From: Susan Haley <Susan.Haley@arun.gov.uk> **On Behalf Of** Planning
Sent: 17 February 2025 15:56
To: Planning.Responses <Planning.Responses@arun.gov.uk>
Subject: FW: Comment On Planning Application AB/6/25/PL

We are writing regarding the planning permission application reference AB/6/25/PL pertaining to Sparks Yard , 18 Tarrant Street, Arundel. We are the owners of the Piano Store 18a Tarrant Street and our property is immediately adjacent to the rear of Sparks Yard.

## **PARTLY IMPLEMENTED AND PROPOSED EAST AND WEST ELEVATIONS**

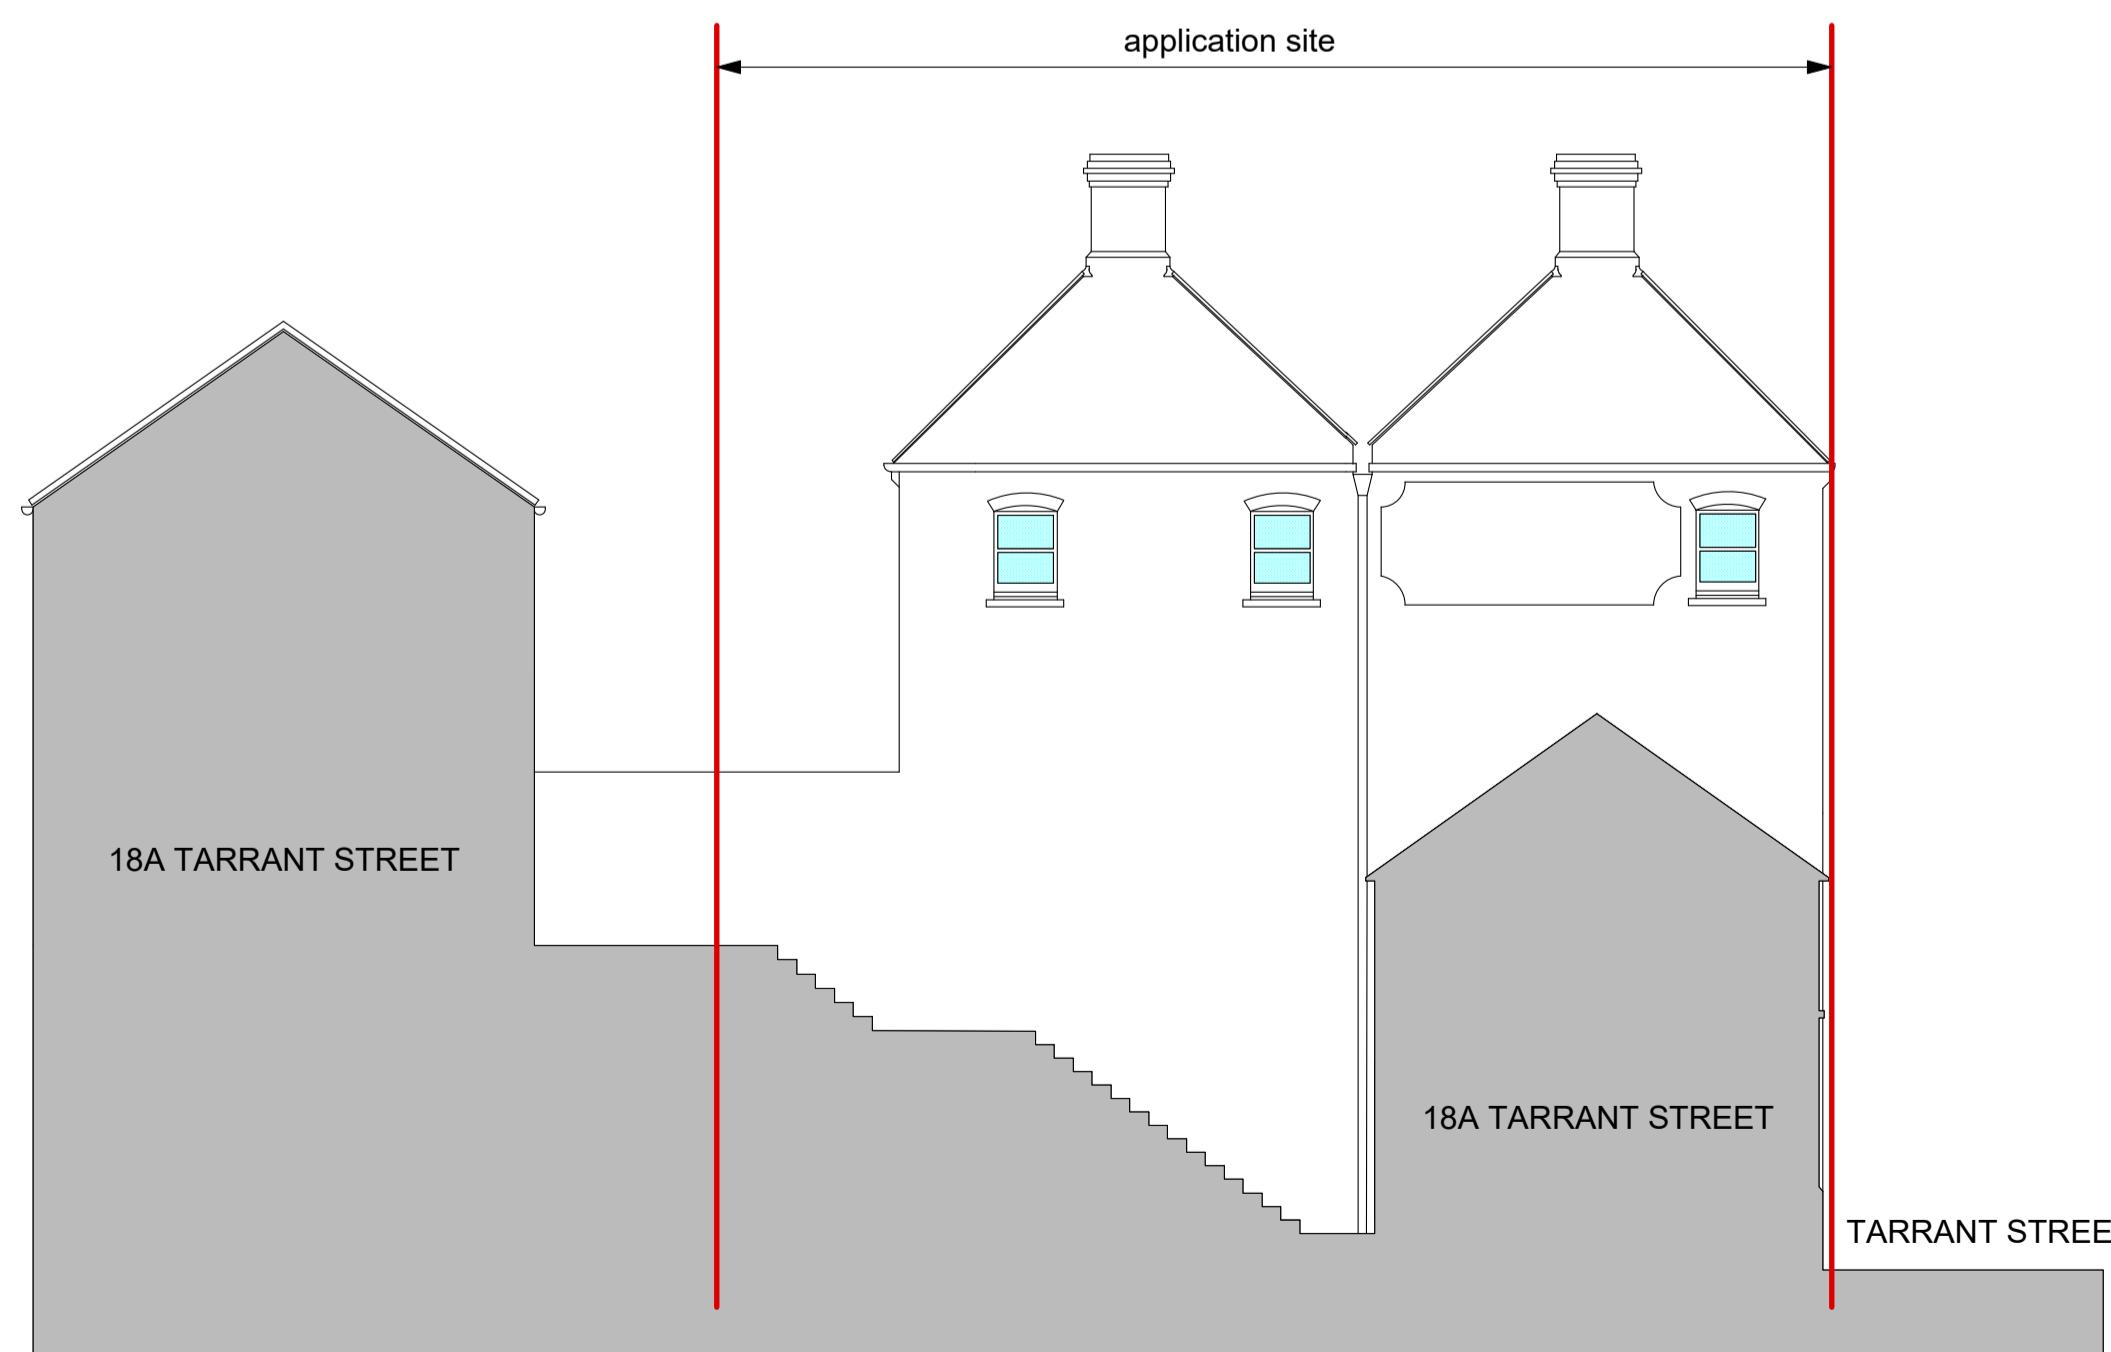
- 1.) The buildings are only 3.6 meters apart north to south elevations
- 2.) The windows on the 2nd floor of Sparks Yard are directly aligned with the Piano Store. Therefore, the conversion of sparks Yard into multiple houses/ occupancy, with either bedroom or living space would have a huge impact on the privacy of the Piano Store. Any new occupiers would be looking directly into our bedroom spaces.
- 3.) The windows on the 2nd floor western elevation look directly over and down into the garden of the piano store. Conversion into living or bedroom areas at this end of the building would again severely impact our privacy and ability to enjoy the amenities of our garden.
- 4.) The windows on both the north and west elevation of Sparks Yard were historically fitted with an opaque glass which in the past protected the privacy of the Piano store. This has recently been removed.

Photo 5. This shows the position of the windows on the west elevation of Sparks Yard which directly look over and down into the garden of the Piano Store

As a last point we do recognise that Sparks Yard needs to find its future use. If the application was amended, or a condition is attached to the planning consent which ensured that the windows we have highlighted are fitted with permanent opaque glass or a fixed louvre system which preserved both parties' privacy then we would have no broader objection and could support the application. This would seem a very fair request as the conversion could proceed into 3 residential units but at the same time our privacy and use of the amenities of our property could be preserved.

PARTLY
IMPLEMENTED AND
PROPOSED SECOND
FLOOR LEVEL PLAN

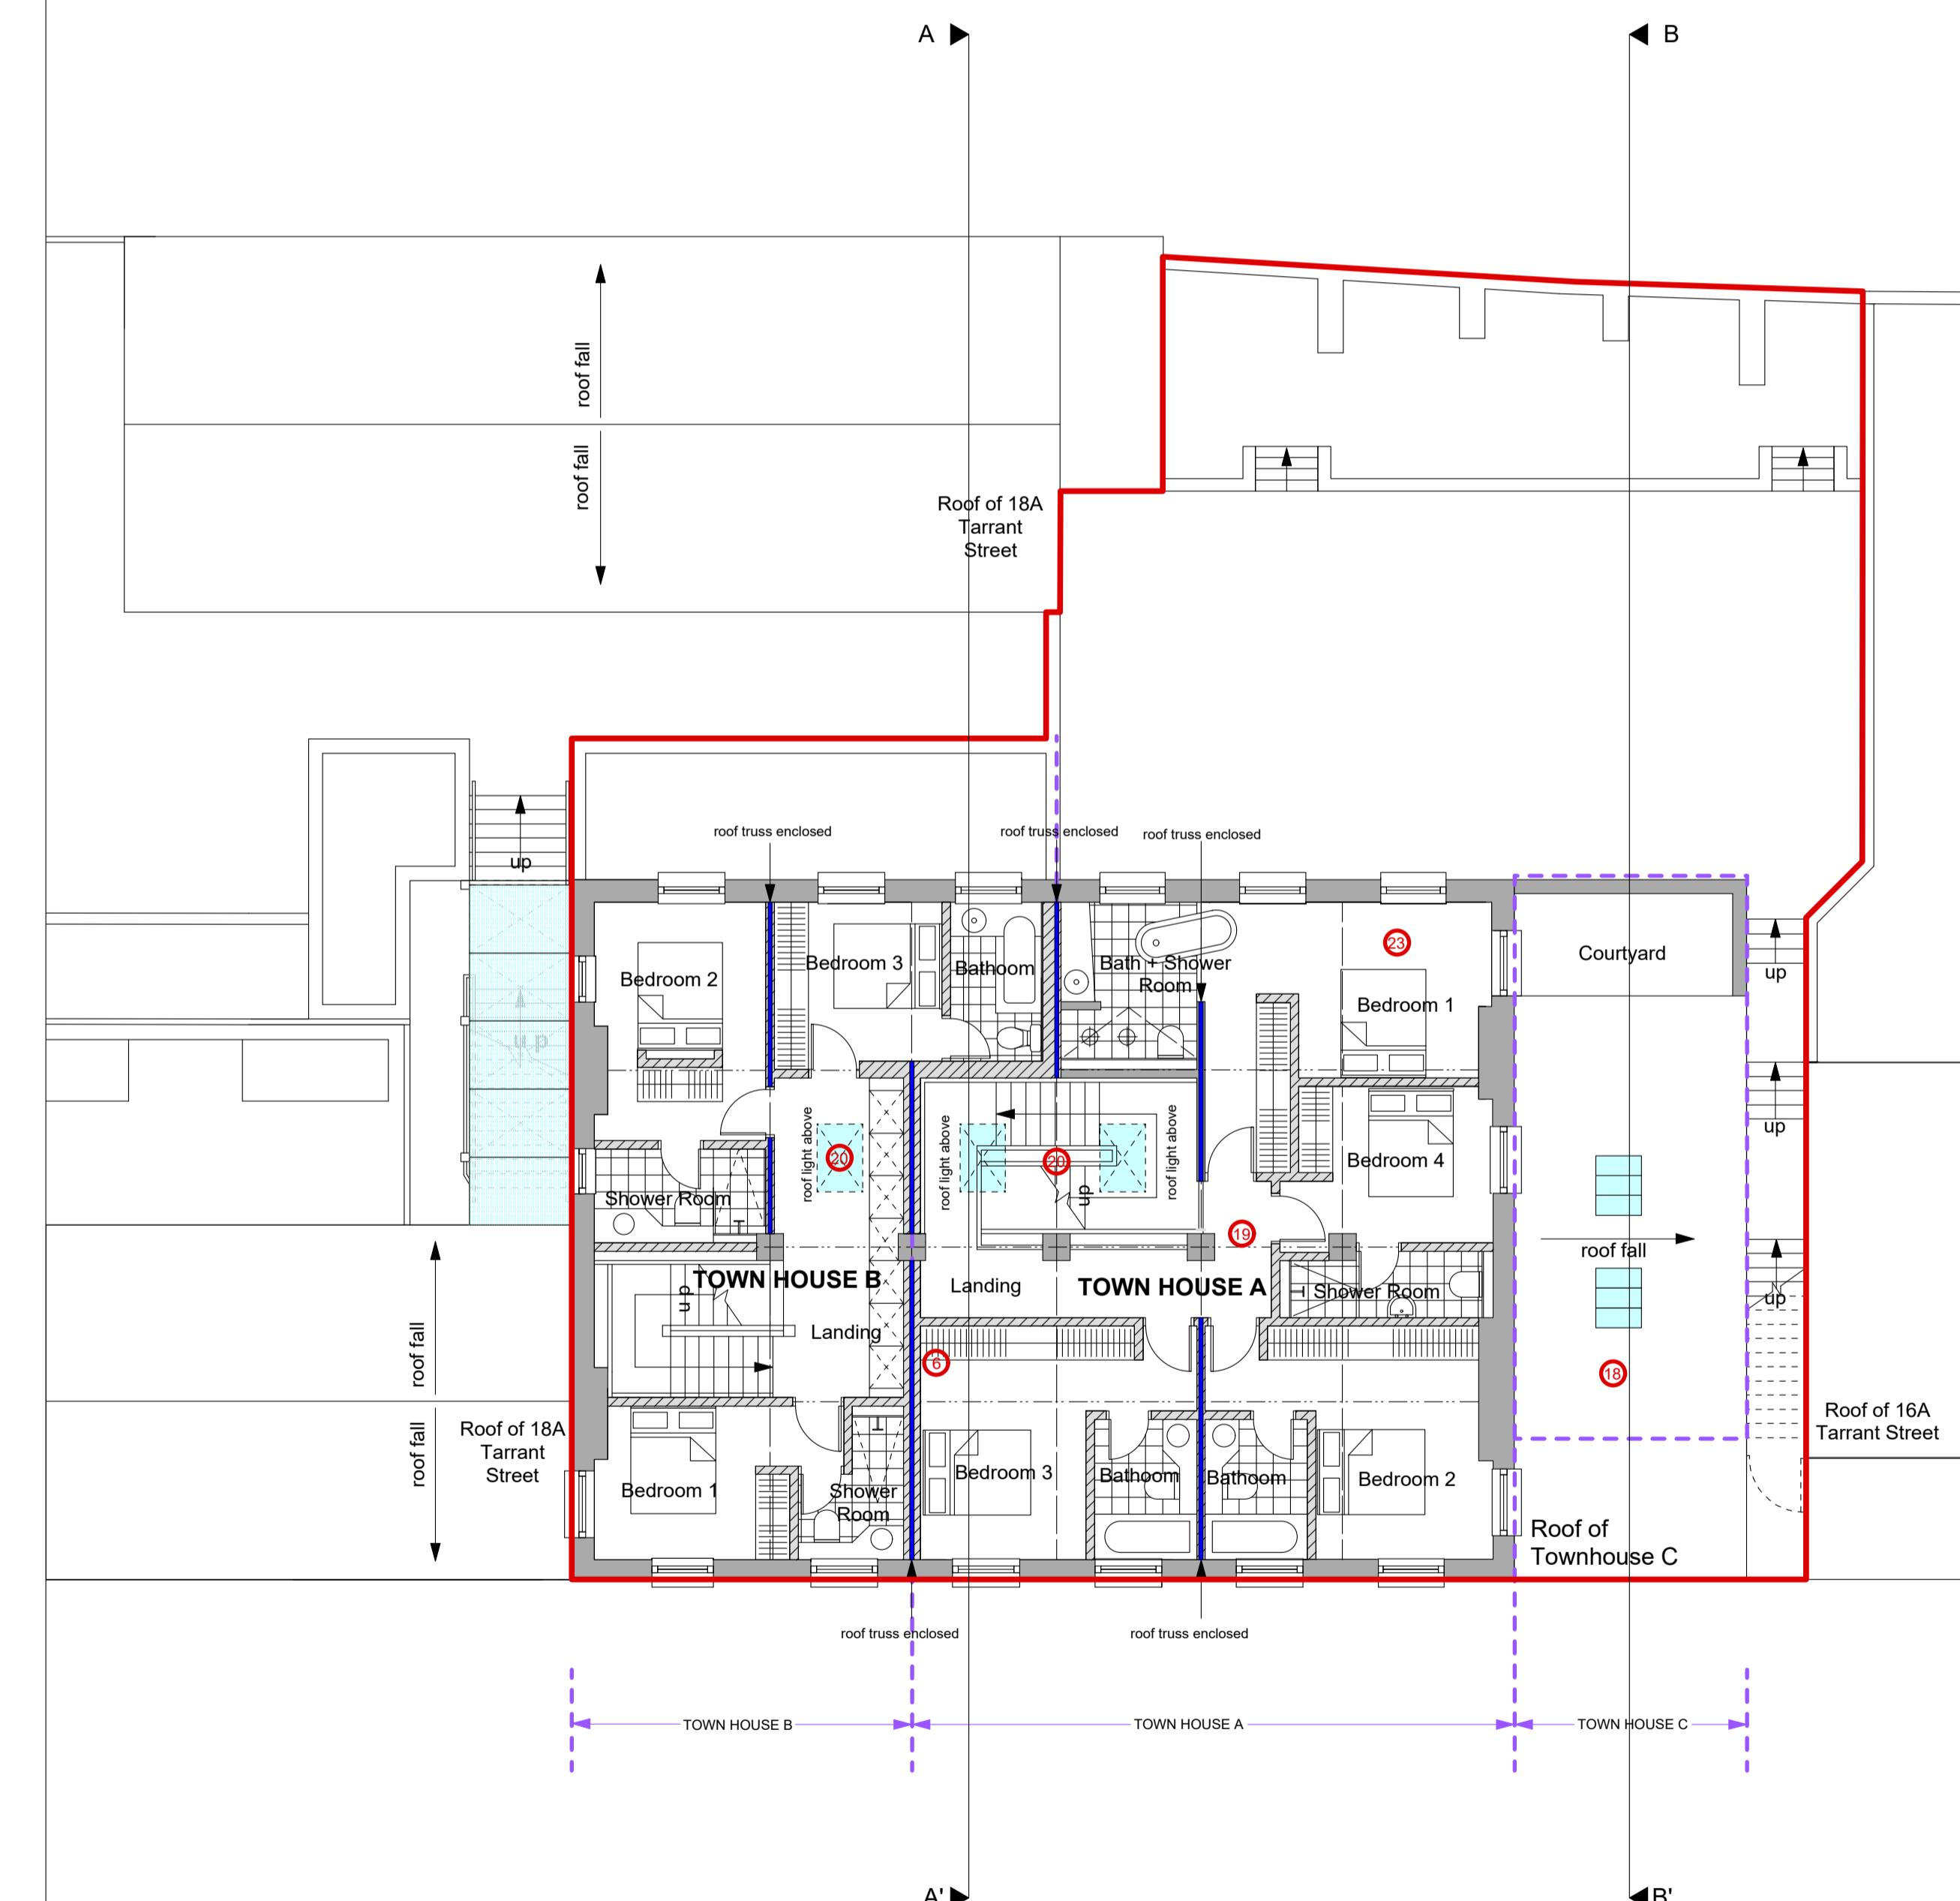
Photo 2. Shows the direct alignment of the windows in Sparks Yard and the Piano Store bedroom 1

Photo's 2 & 3. Shows the direct alignment of the windows in Sparks Yard with the Piano Store bedroom 2
